**WALBERTON PARISH COUNCIL
INCLUDING FONTWELL AND BINSTED**

Re: Planning application WA/93/20/PL: Land East of Tye Lane, Walberton.

Walberton Parish Council wishes to register an objection to this application. We have the following concerns.

AVISFORD PARK ROAD

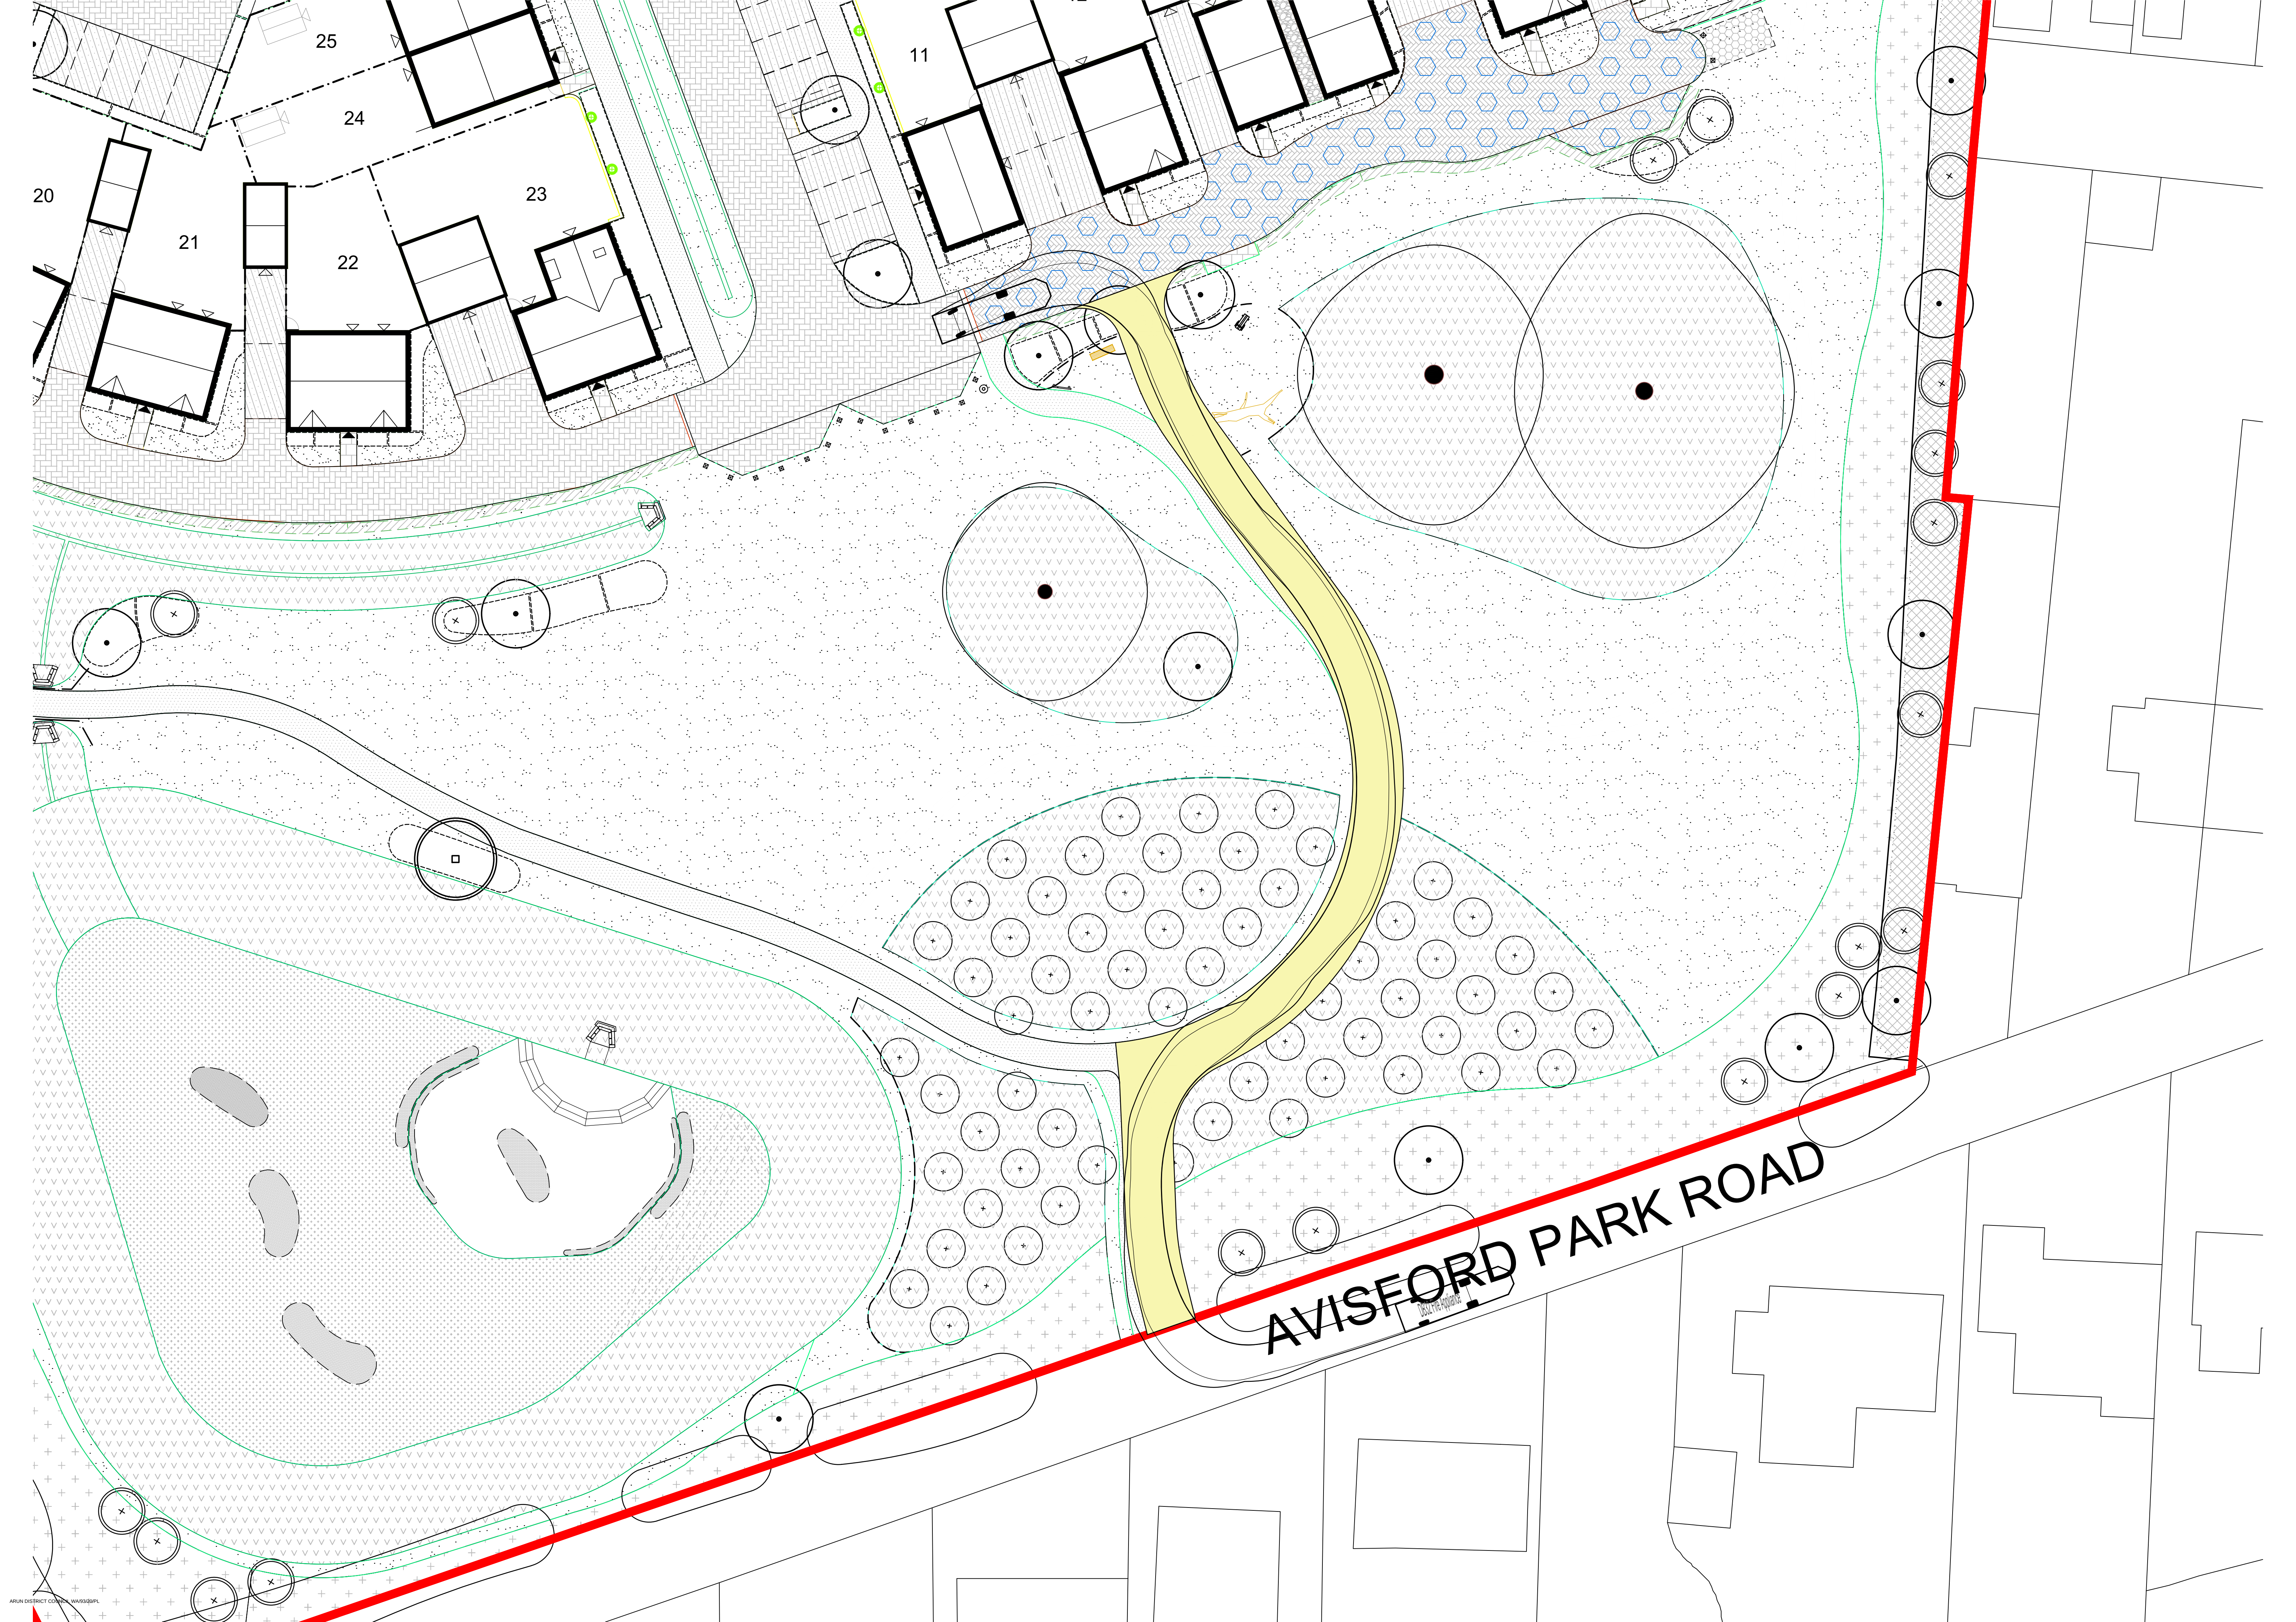
This is considered wholly inappropriate onto this narrow unsurfaced and unadopted road. Fire access is also wrong. The application shows 2-way access. The shown left turn into AG is not possible as Avisford Park Road is only accessible by vehicles from the Yapton Lane end. Therefore, right turn is only possible.

The widened path proposed for emergency vehicles is in the public open space and they have not made clear how this will impinge on this space particularly the safety of users.

The developer considers APR suitable because the council's refuse vehicles use it; but note that the refuse vehicles reverse down the road in order to drive back out.

APR is only wide enough for a single vehicle only, two vehicles cannot pass each other, it is frequently blocked by parked cars and delivery vehicles, and is used once a year for a community street event

In the title for Tupper's Field, now the Avisford Grange development, the developers have no legal right of access onto Avisford Park Road.
